ISH5 Action 8: points to be made in addition to previous submission

ISH5 Action 14: how and why LTN 1/20 should be embedded in the design principles document

Appendix C of the design principles document

Rev: 01/01/2022 10:25:27  
File Name: C:\P\WORKING\DCO\WORKING\DCO\HE551495-ACM-LSI-ZN1\_SW\_Z\_ZZ-DR-DC-2672

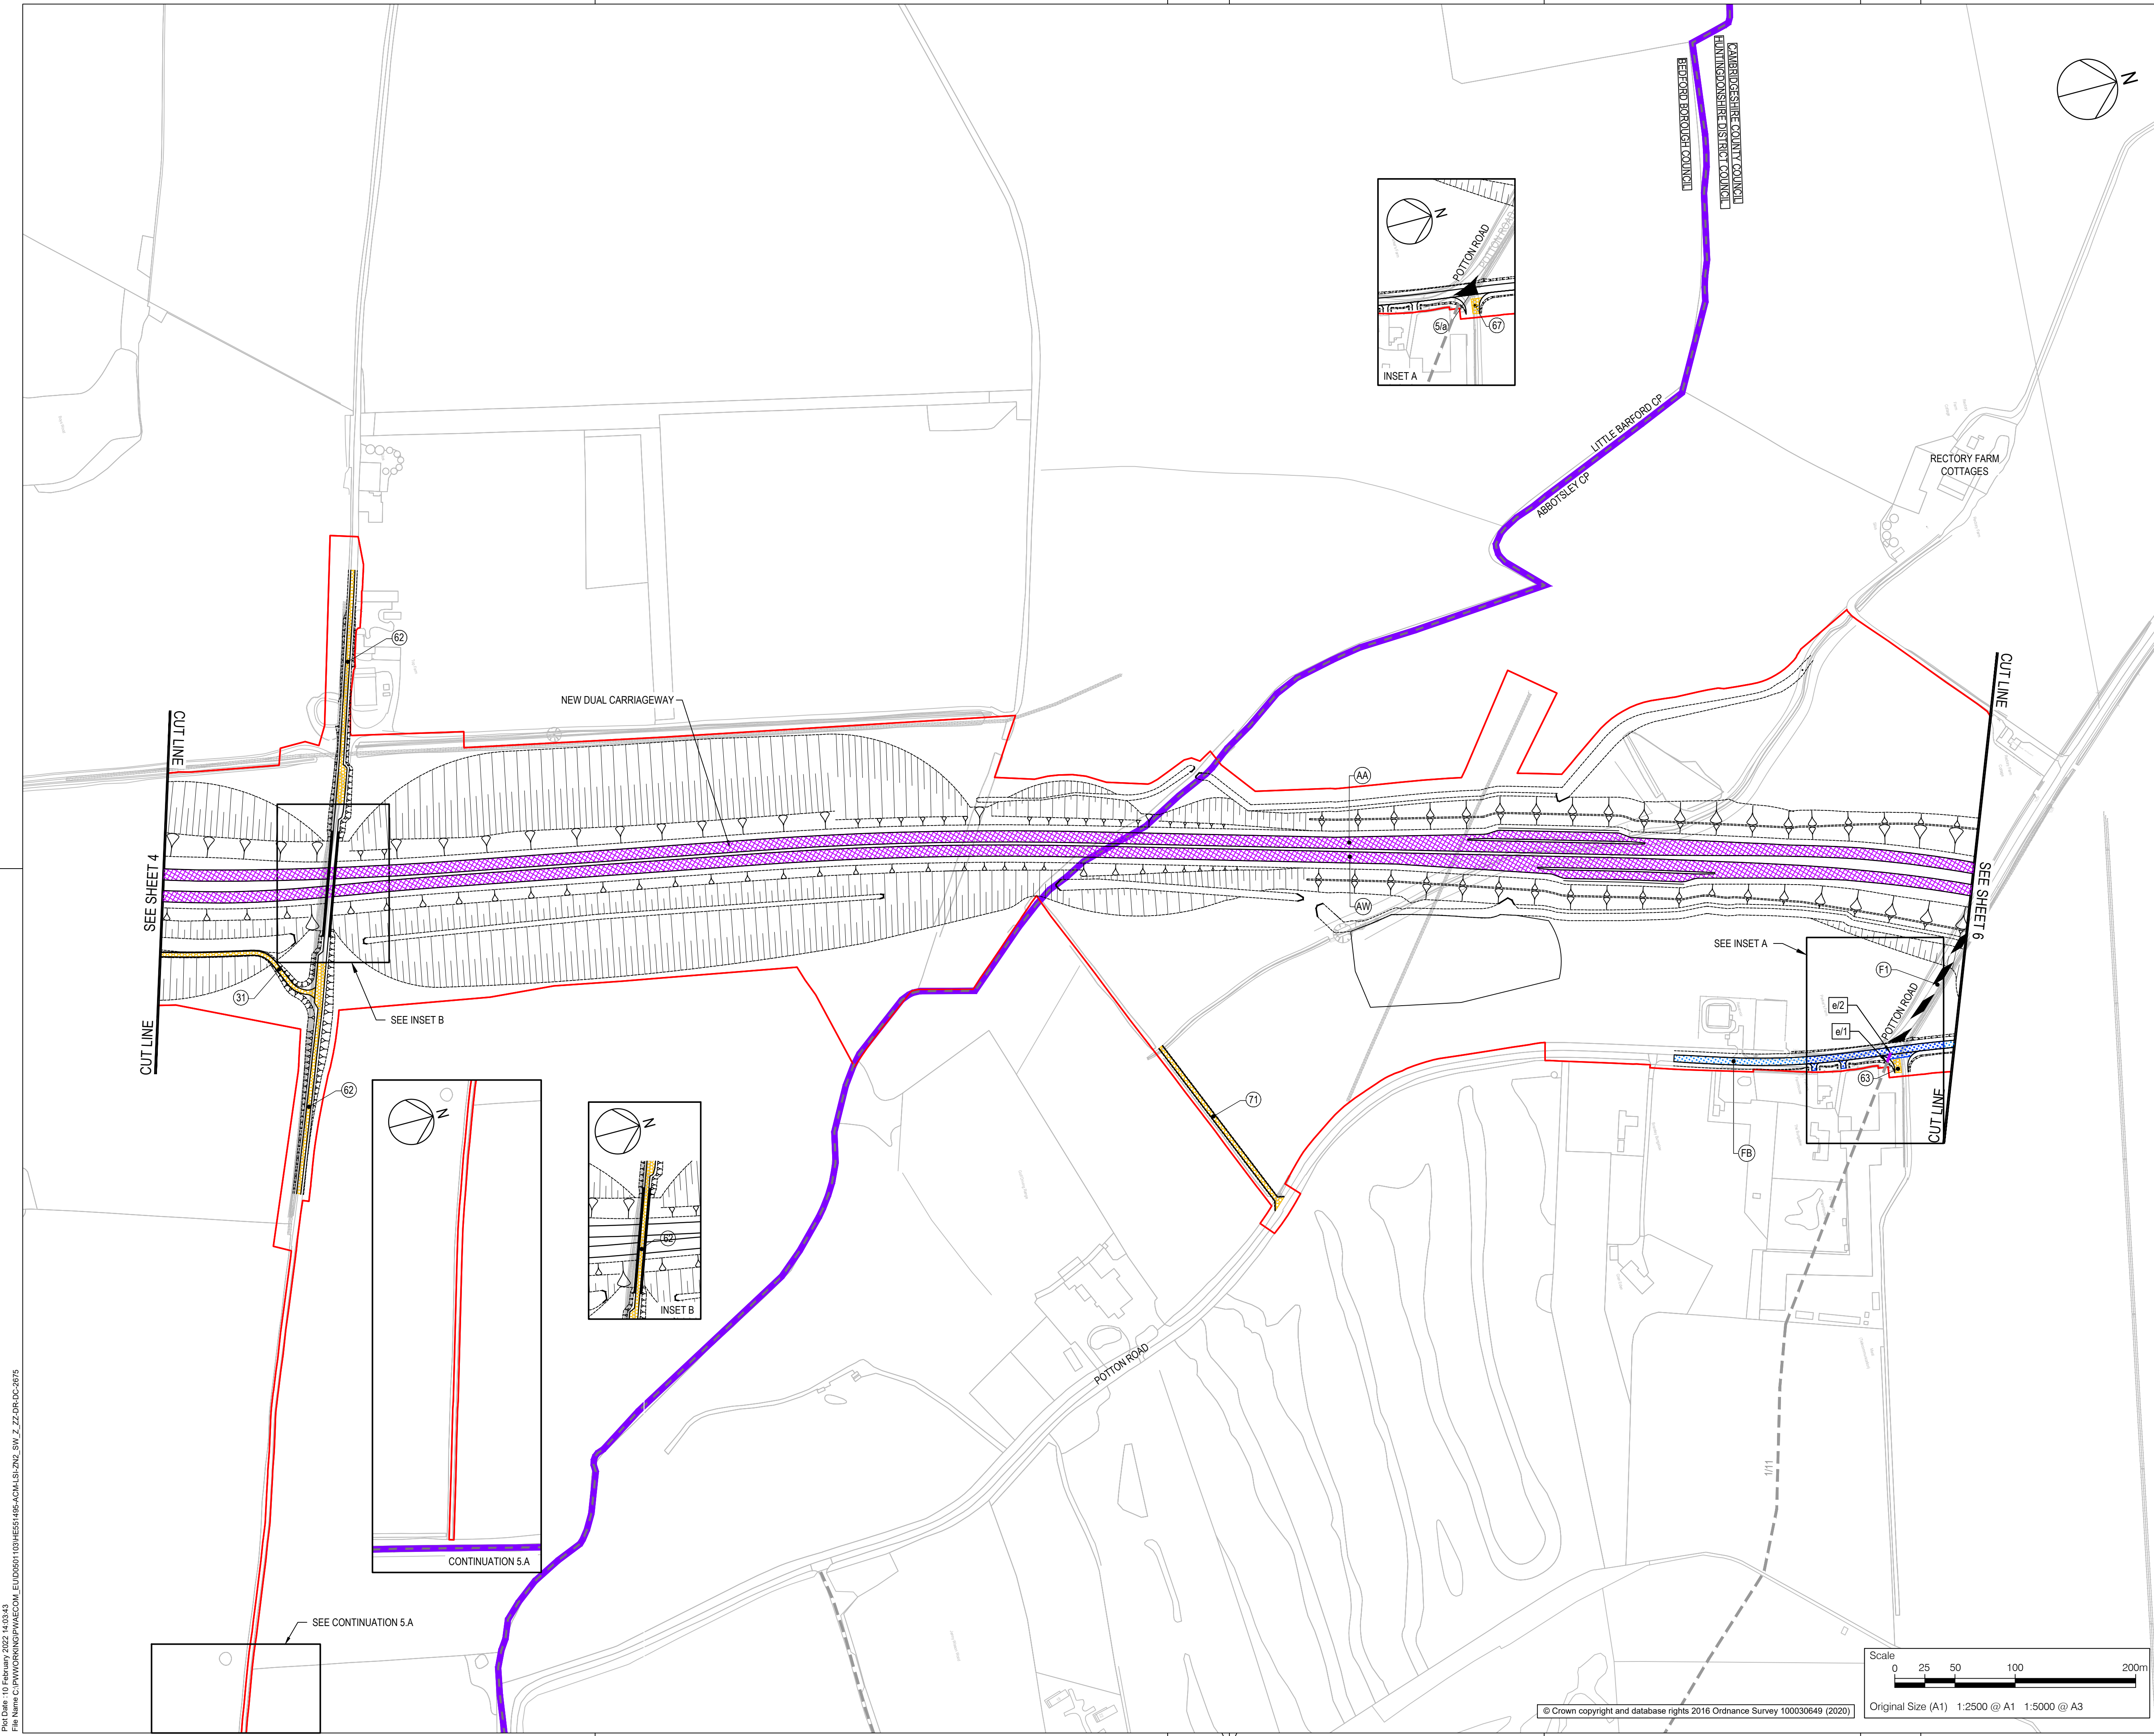
- Sheet 1 Composite drawing ending with DR-DC-2671 (Black Cat Junction): none of the active travel routes north of the Kelpie Marina Access Road appear to have any separation from the carriageway, apart from locations in the vicinity of junctions where thankfully there is some separation.
- Sheet 2 drawing ending with DR-DC-2672 (Roxton Road link north): none of the active travel routes appear to have any separation from the carriageway, apart from locations in the vicinity of junctions where thankfully there is some separation.
- Sheet 9 drawing ending with DR-DC-2679 (New Cambridge Road Junction): none of the active travel routes appear to have any separation from the carriageway, apart from locations in the vicinity of slip road roundabout entries and exits, where thankfully there is some separation.

- Sheet 1 Composite drawing ending with DR-DC-2671 (Black Cat Junction): Roxton Road roundabout has a crossing of one arm where drivers may be able to turn the corner at high speed and put active travel users in danger.
